## Portland Public Works - Engineering

**Subject:** 22 Bramhall Street\_MMC East Tower & Visiting Parking (2017-289)

The following comments/concerns are in regards to the Level III Site Application prepared by Sebago Technics, on behalf of the applicant, Maine Medical Center, with last plan revision submitted on February 22, 2018. Please feel free to contact me with questions.

Congress Street Detour

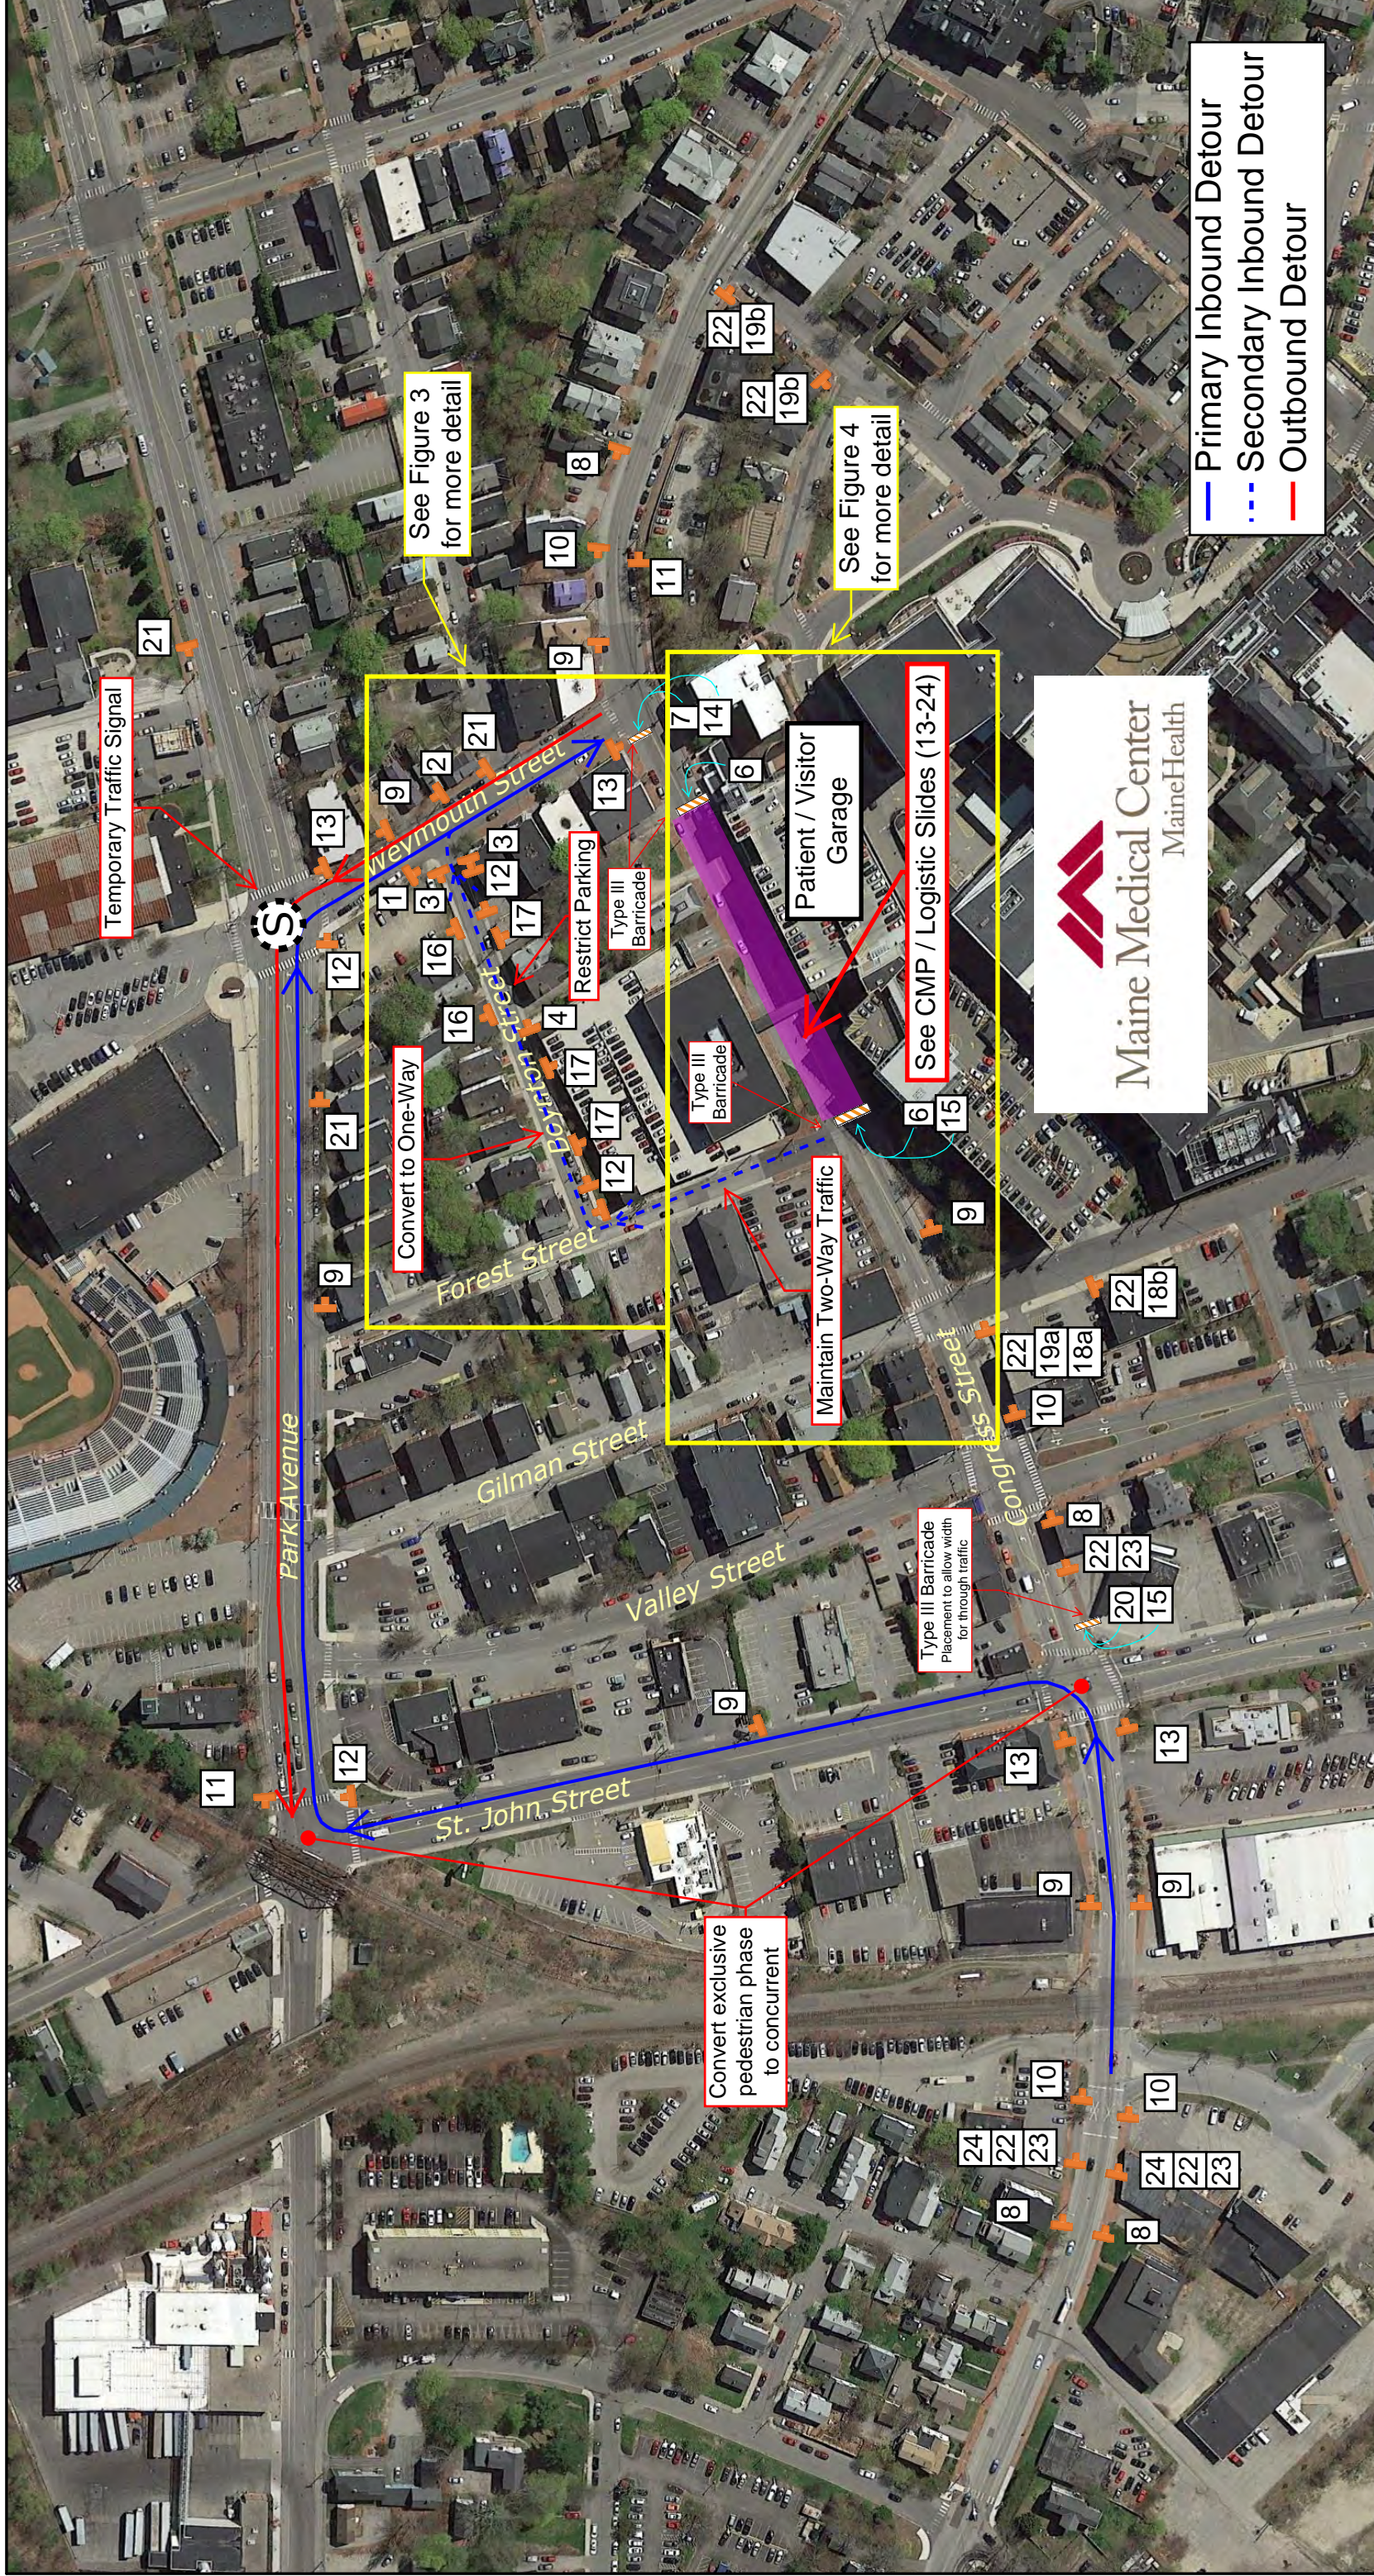
- 1.) Weymouth Street is in poor condition, and with the significant increase in traffic, including heavy vehicles, the infrastructure is not capable of accommodating additional traffic. In order to maintain a tight construction schedule, the applicant shall pursue a two-step course of action.

- a. First, a short-term paving/patching project shall be considered to stabilize Weymouth during the course of the detour project.
  - b. Second, a more comprehensive outcome shall be constructed post detour, which would ideally address the unusual crown of the road. As with any paving project done in Portland, ADA considerations shall be part of the outcomes.

- 2.) Paving conditions for Forest and Boynton Streets shall also be investigated and any interventions/mitigation identified for those streets included in outcomes.

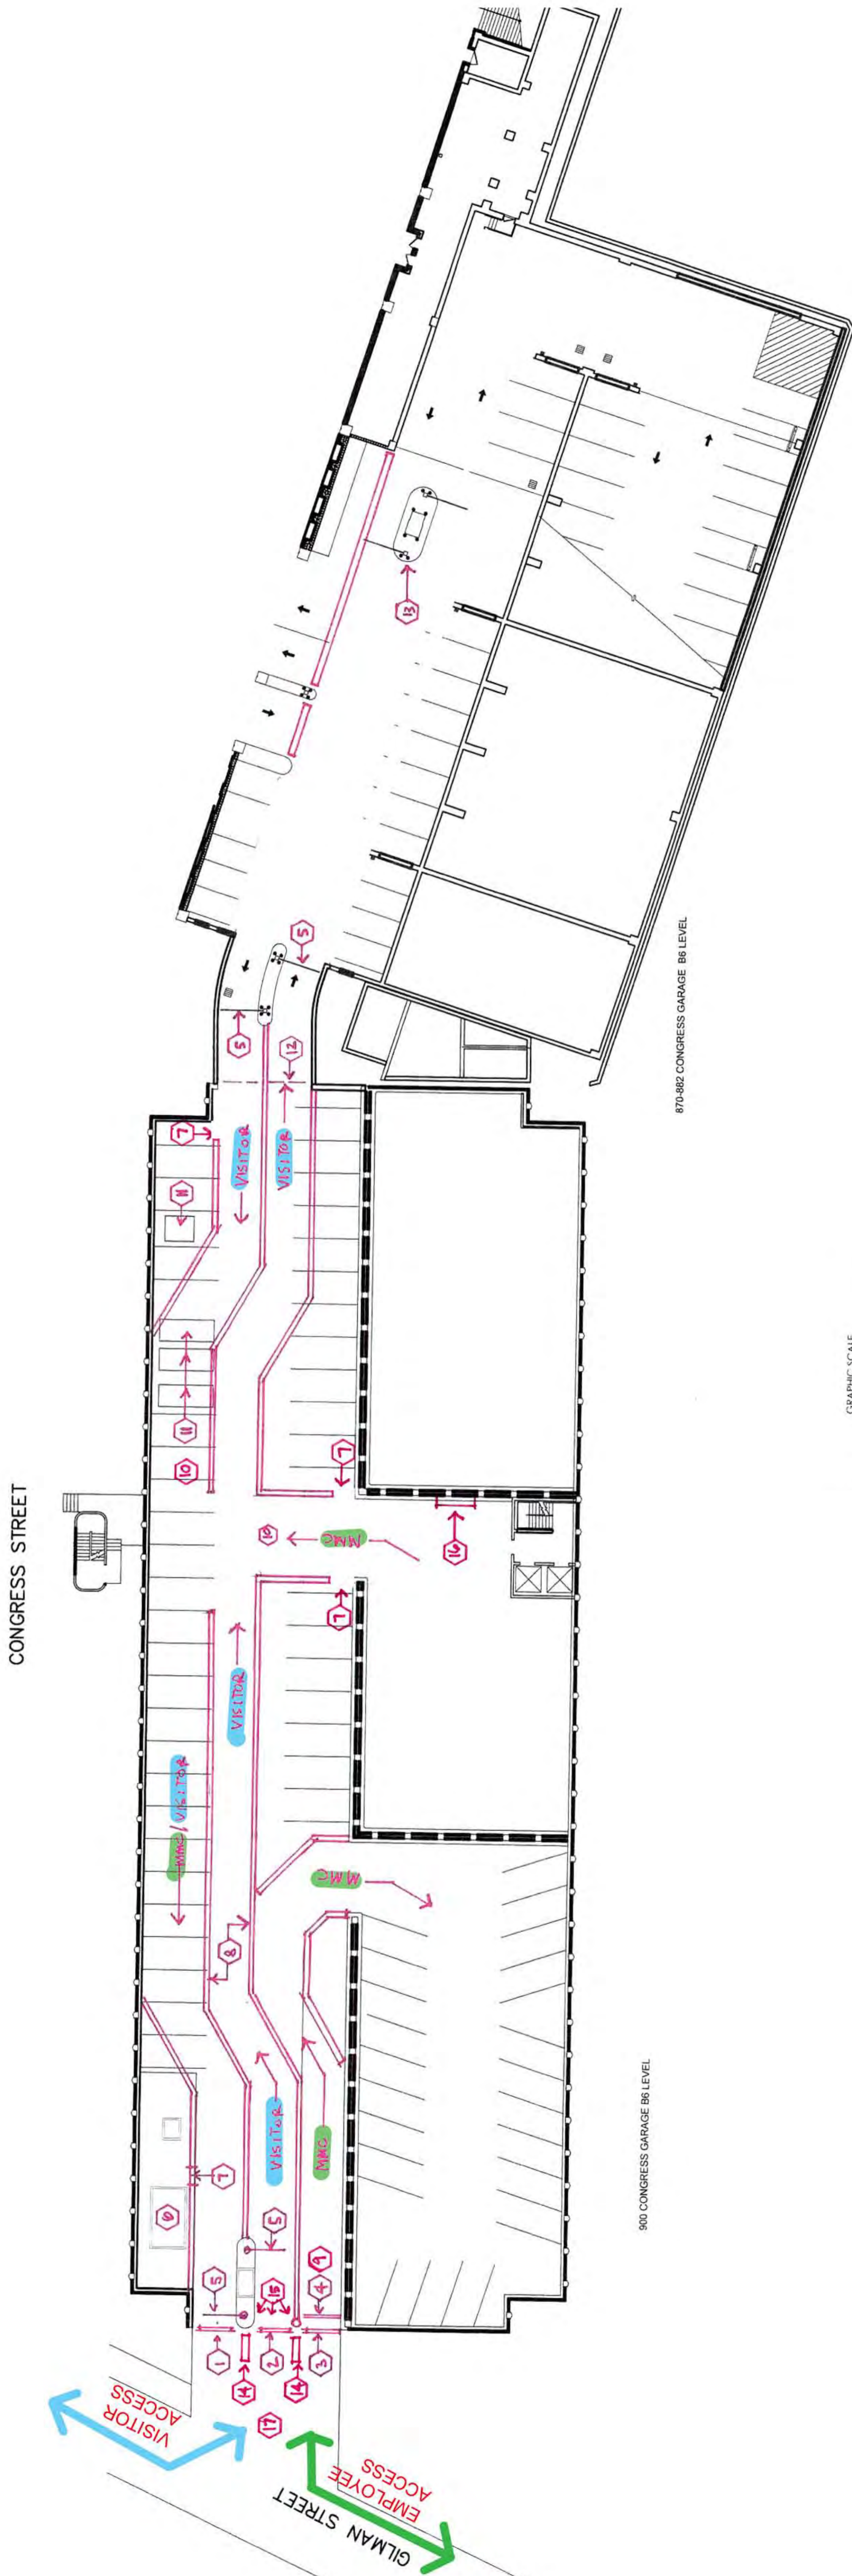
- 3.) More detail needs to be provided on the temporary traffic signal to be located at Weymouth Street and Park Ave. The signal shall meet all state and federal requirements for operation, and accommodation of pedestrians. Details shall be provided on timing and potential time of day or direct coordination with adjacent signals at St. John Street and Deering Ave. The location shall be monitored to determine operation and a count completed after two weeks to determine if the location is

operating as intended. Consideration shall be given to whether this location would likely make a more permanent signal location candidate.
